The change of use of land for the storage of building materials, equipment & plant & for the parking of 2no. articulated vehicles together with part boundary screen fence.

Babsham Business Centre Babsham Lane Bersted

Thank you for your internet representation made on 19th August 2019 which has been recorded as '**an objection**' with the comments as follows:

PROPOSED SITE PLAN - 1:200

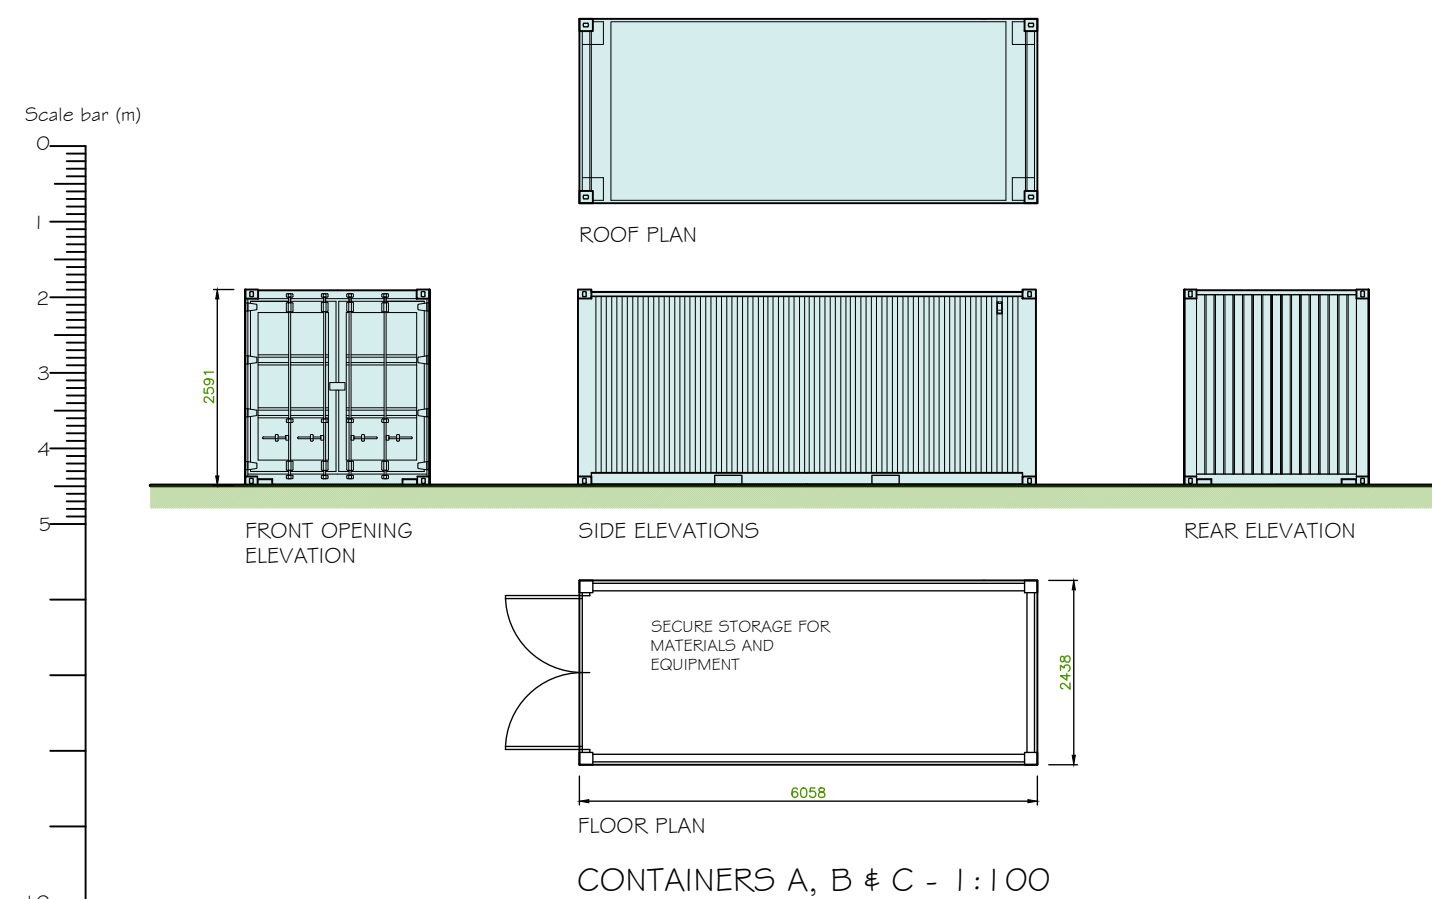
A further objection concerns the erection of a 2.4m close boarded screen fence on the SW boundary of the site. Had the agents of the Church Commission paid us the neighbourly courtesy of sharing their plans with us prior to submission, the futility of constructing a 2.4m fence running adjacent to an existing 1.7m brick wall which separates our property from the area marked on the plan as 'existing vegetation retained', would have been immediately evident. As it stands, a request will now be made directly to the Planning Officer for a visit to this property in order that the anomaly of this particular proposal be established and verified.
